Application number: 2021/94410	
What is the application for?:	Outline application for erection of residential development
Address of the site or building:	land at, Olney Street, Slaithwaite, Huddersfield, HD7 5EG
Postcode:	HD7 5EL

Type of comment: An objection	
Do you wish your comments to be published on the website anonymously?	No

Site Plan 1:500

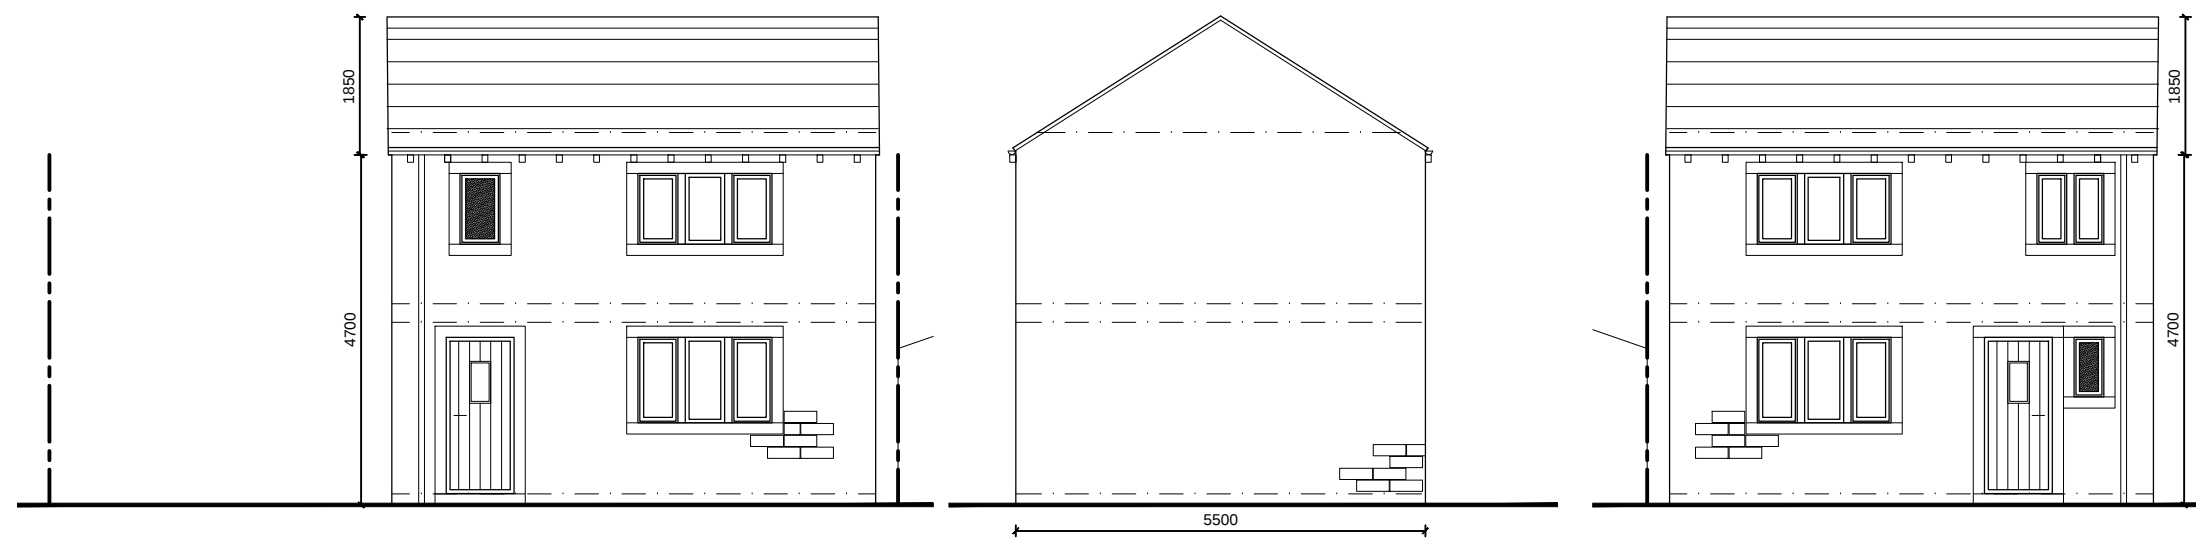
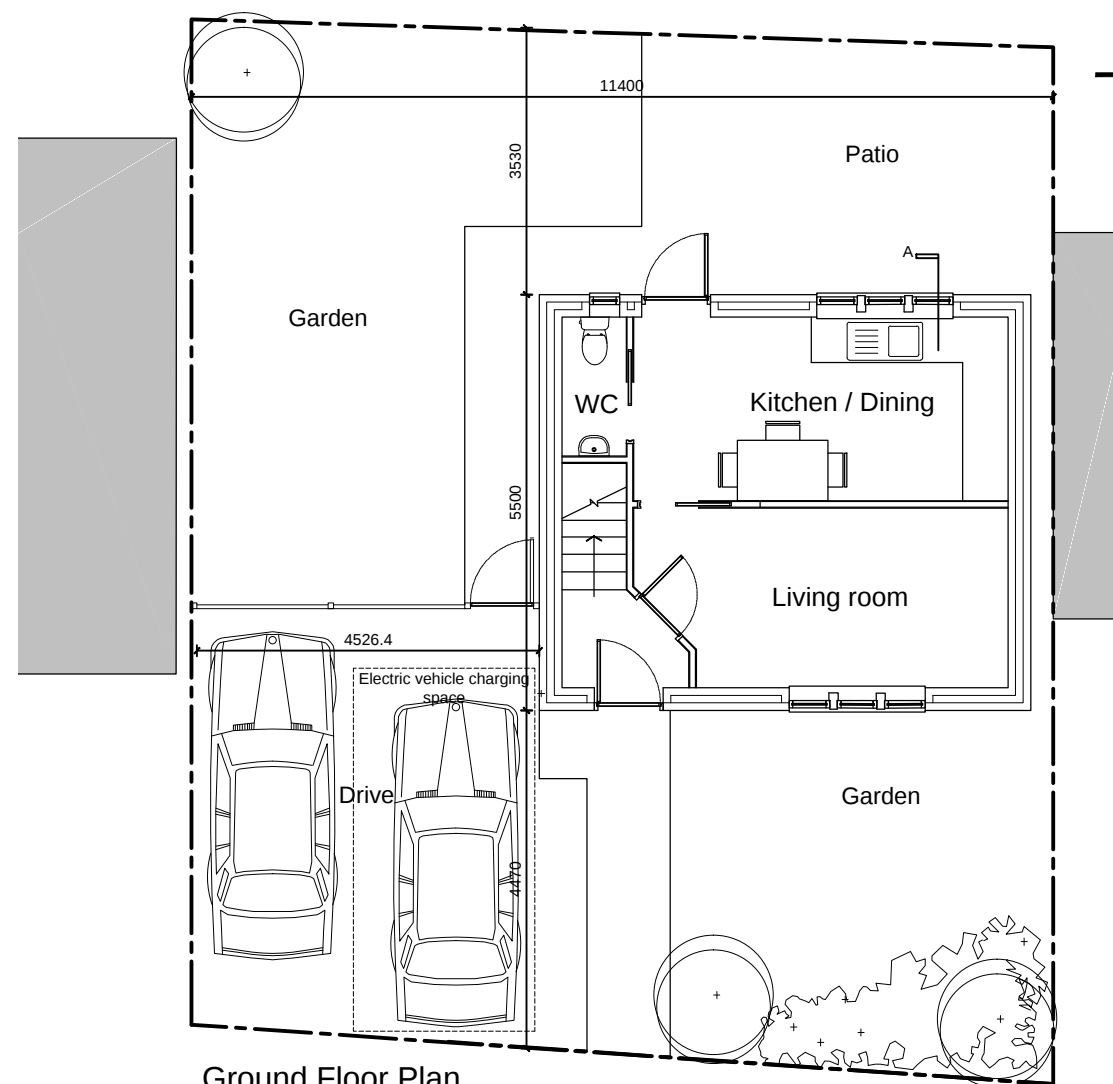
I live opposite the planned development and like in the previous application made for the site feel that the building of a home on the plot will obstruct my view of the surrounding countryside and also mean that a further property as before in the last application, will be able to see into and overlook my property. The building will also not be in keeping with the style of property in the area which are predominantly Victorian terraces. Other developments on OLNEY STREET have taken this into account and been built in a sympathetic manner to match the present Victorian terraces. This property will not do that.

I also currently park my large work van on the adjoining plot. My access to this plot would be eliminated as the turning circle available for my vehicle would be reduced by the plot being built upon. This would deny me a safe off the highway place to park my van and force me onto the street causing yet more congestion.

In summary I object as the building is not in keeping with the area in terms of aesthetics, because it will overlook my property, obscure my view of the hills and countryside opposite and cause further congestion on an already full to capacity street vehicular traffic wise.
